Storm Water Management Plan (SWMP) For Construction Activities

Les Schwab Tire Center

Meridian Crossing Filing Number 1 Falcon, Colorado

C3.0

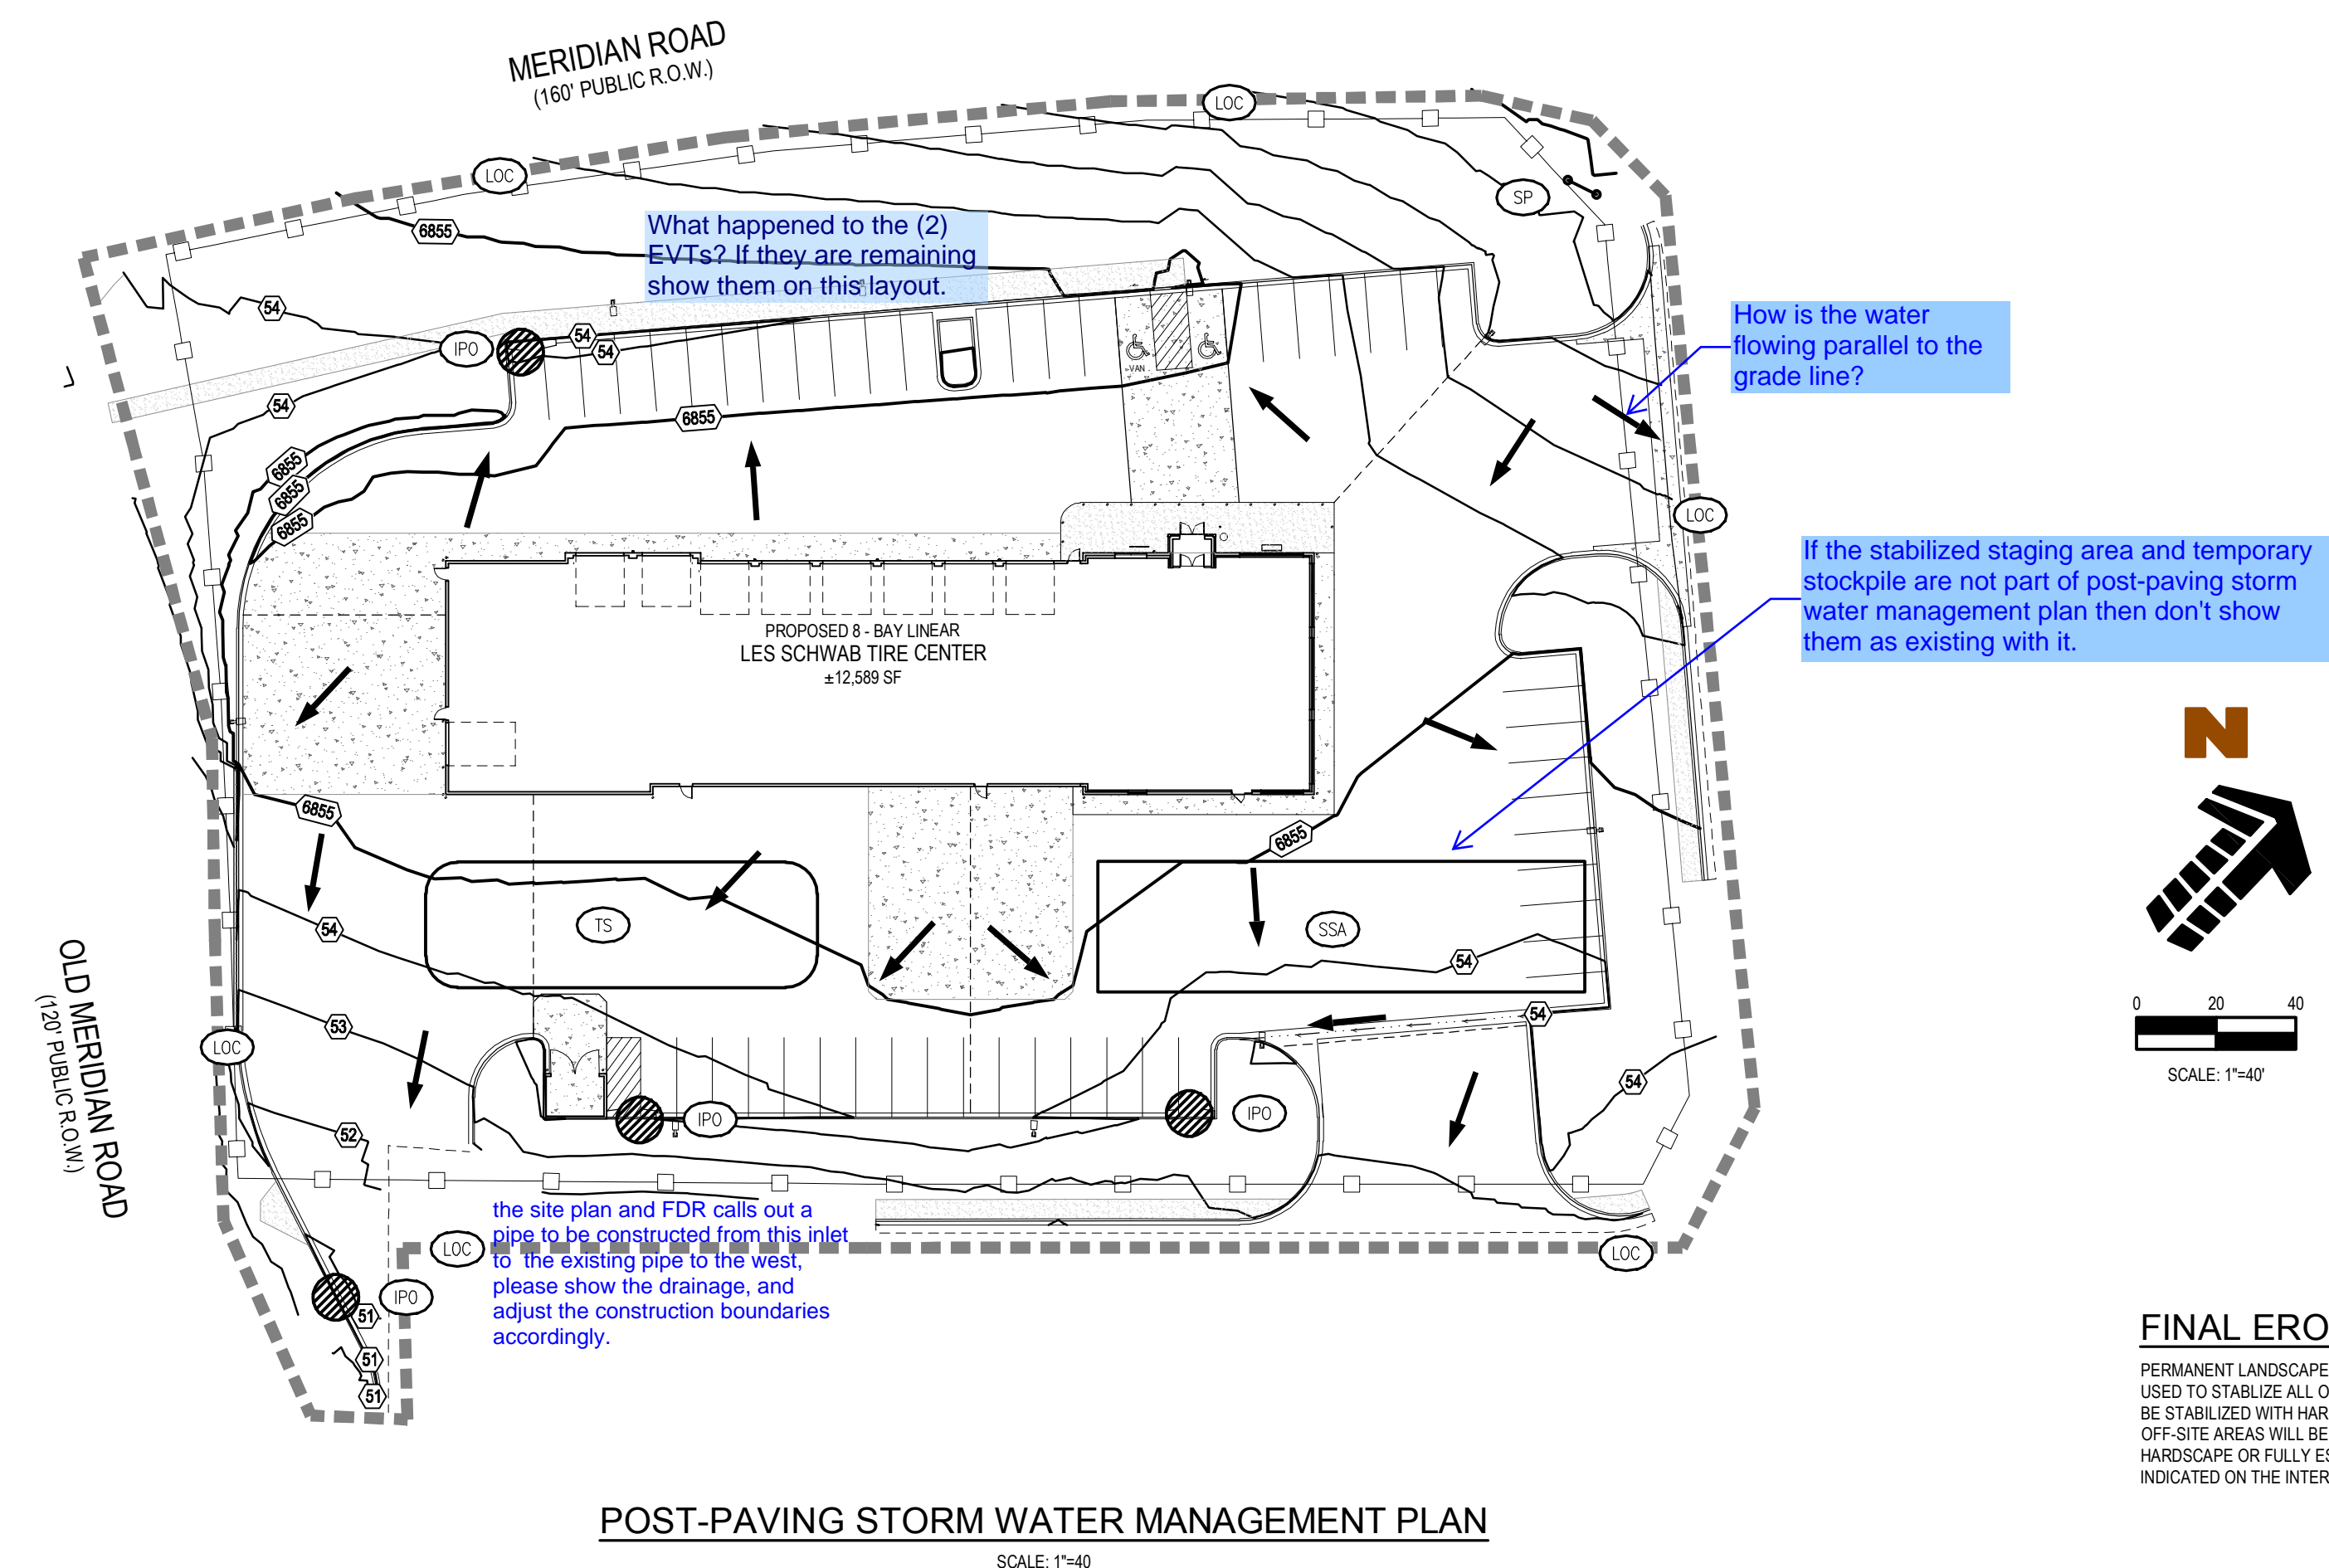
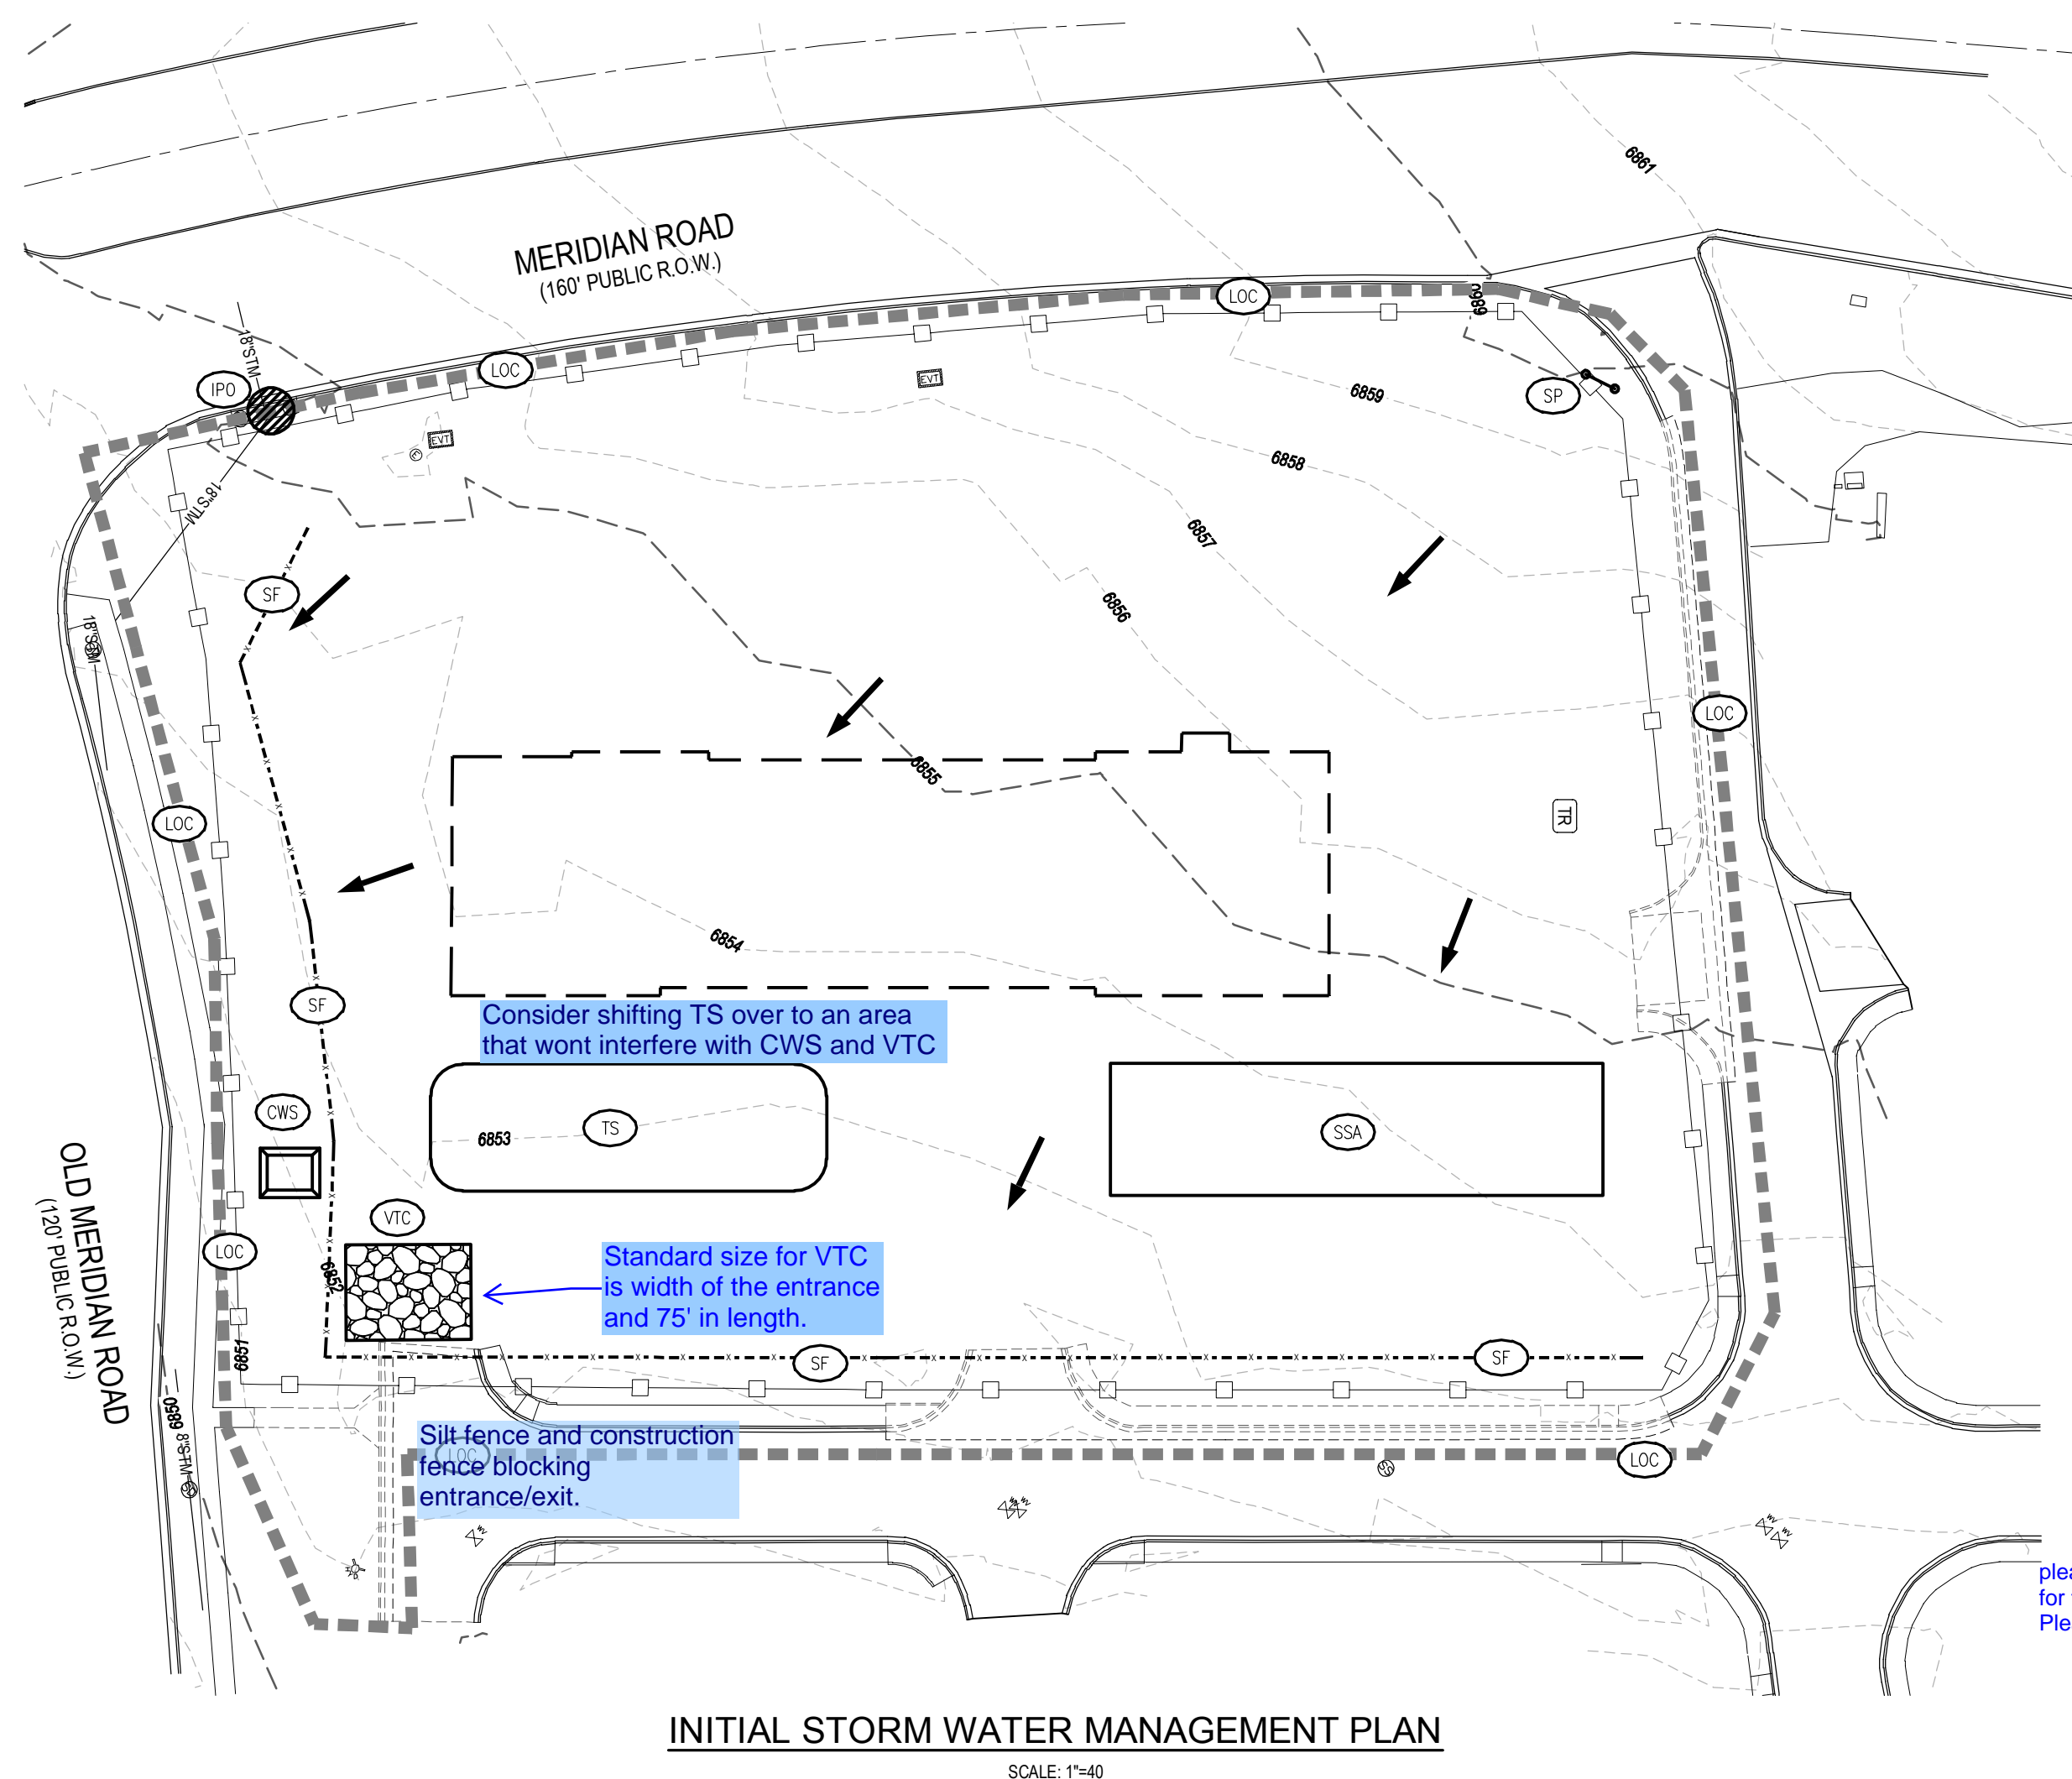
Please confirm sheet numbers.
